Application No: LU/52/12/

Recommendation Report for Planning Permission

LOCATION: 47 River Road
Littlehampton

PROPOSAL: Provision of new floating pontoon accessed via 5 no. access ladders from approved projecting balconies

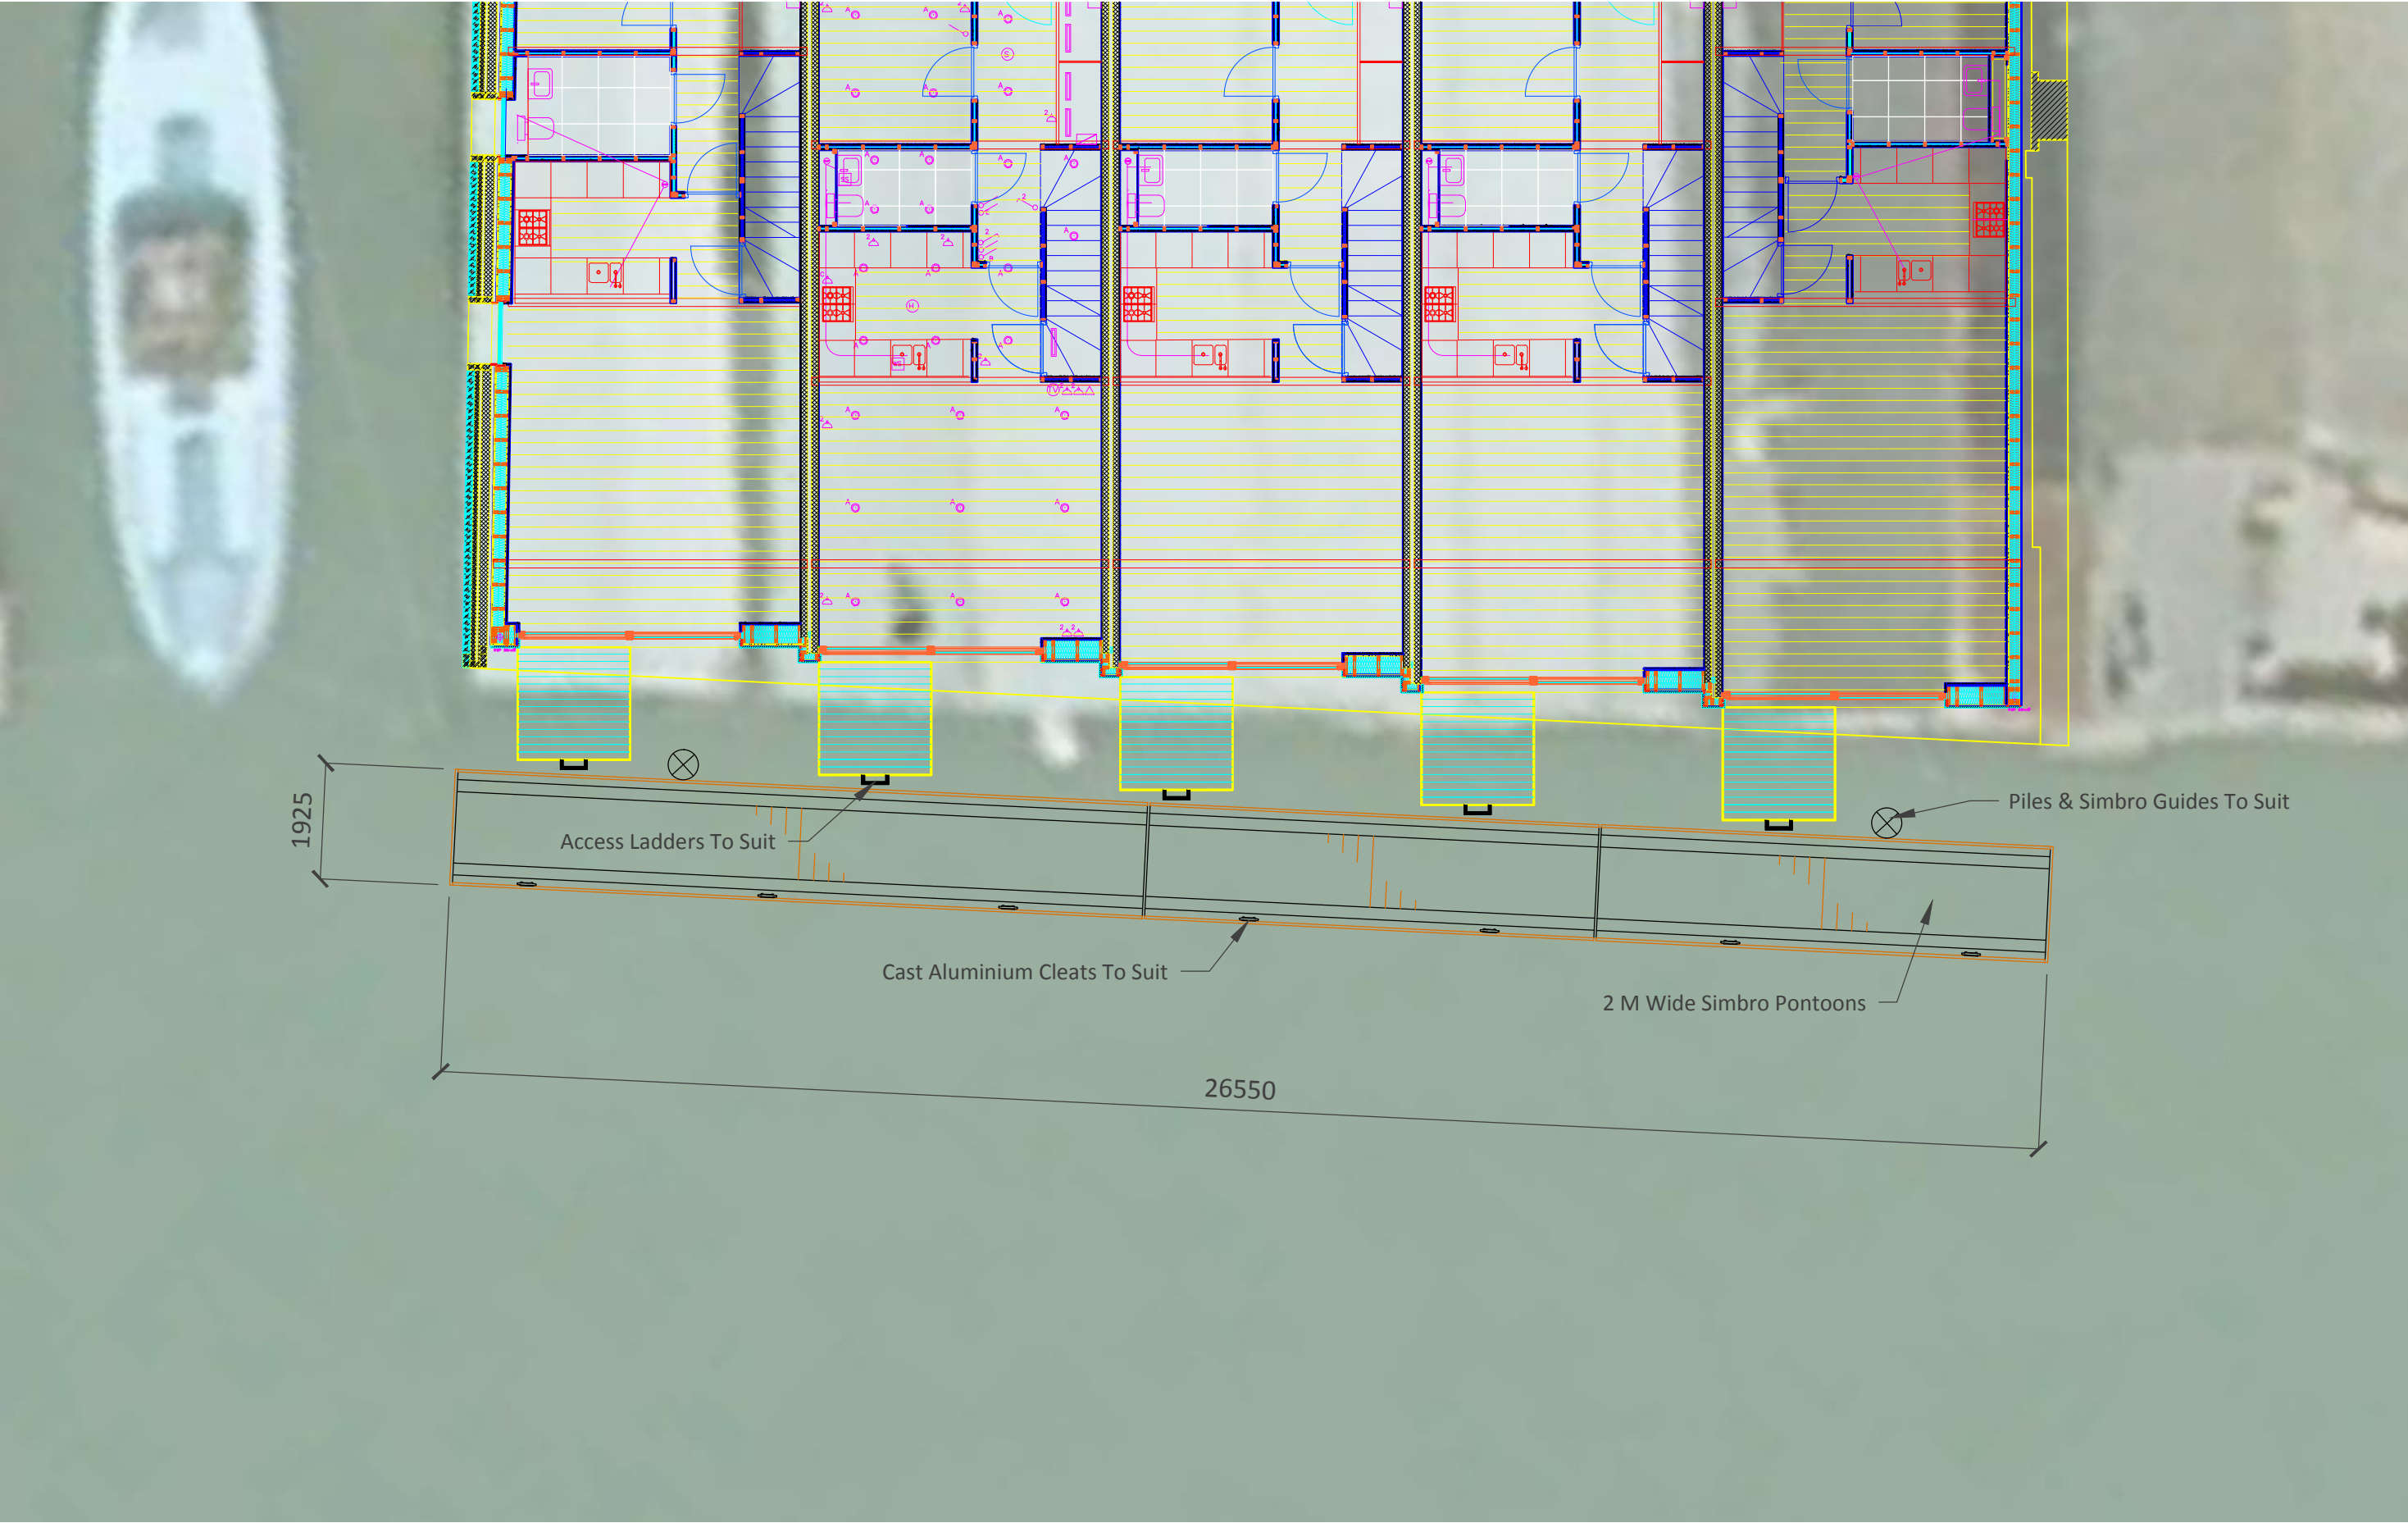
Applicant has complied with request of Harbour Board regarding maximum distance from the existing wall at 47 River Road to the outboard side of any moored vessel at this location not exceeding 6.7m.

The plans show the outer edge of the pontoon is 3.6m from the edge of the building so this allows for a maximum beam of 3.1m which is a sensible allowance for this location.
